Application for Planning Permission for Works or Extension to a Dwelling

Development: Single storey rear and side extension, loft conversion and 1 x rear dormer
Location: 17 Bala Crescent Felpham PO22 8LY

11803.11

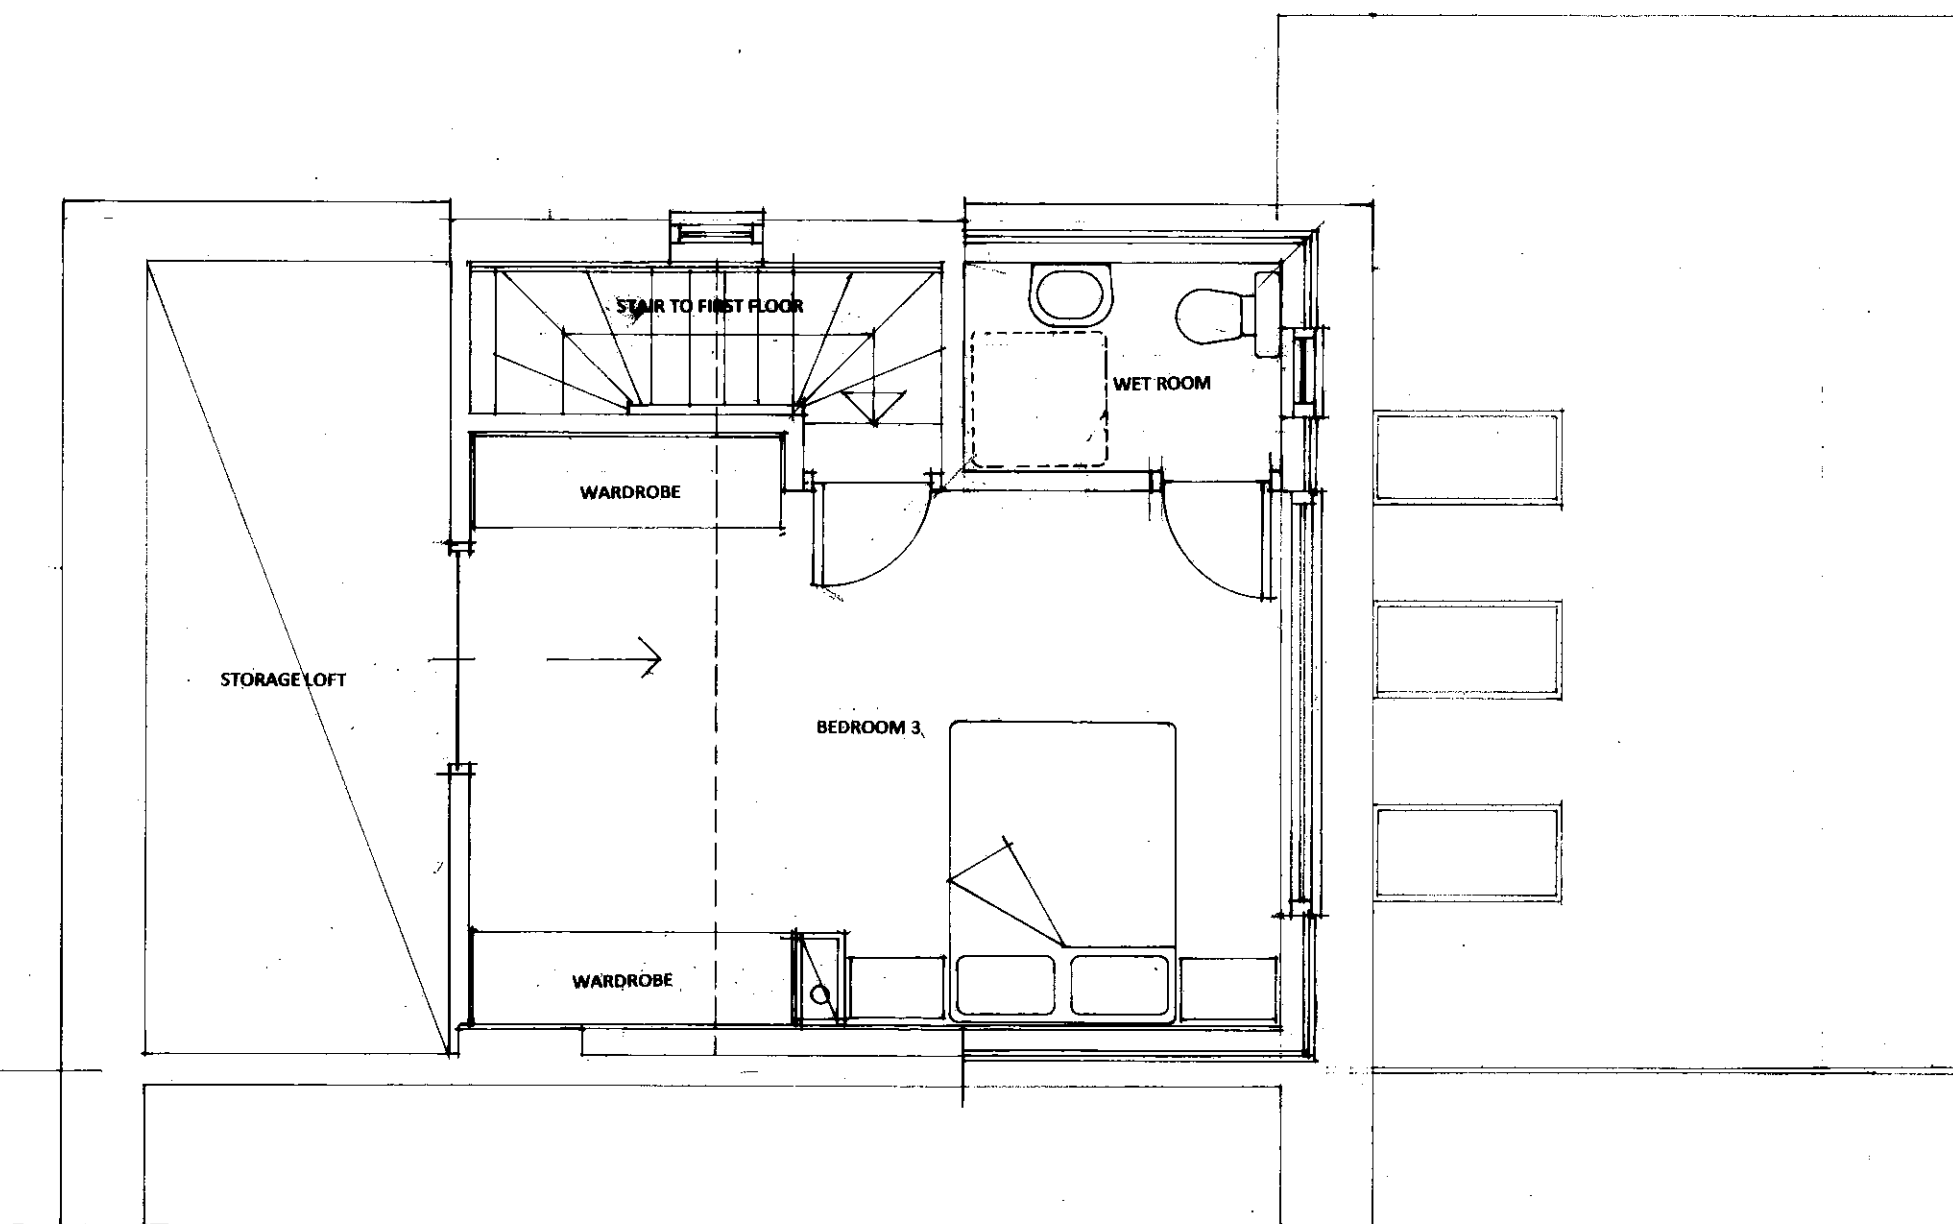
You have submitted two different loft plans under the same drawing title (11803.11 and 11803.09). Please confirm which you wish to submit for this application

The side staircase window on the loft plan is missing from the proposed side elevation. Please amend.
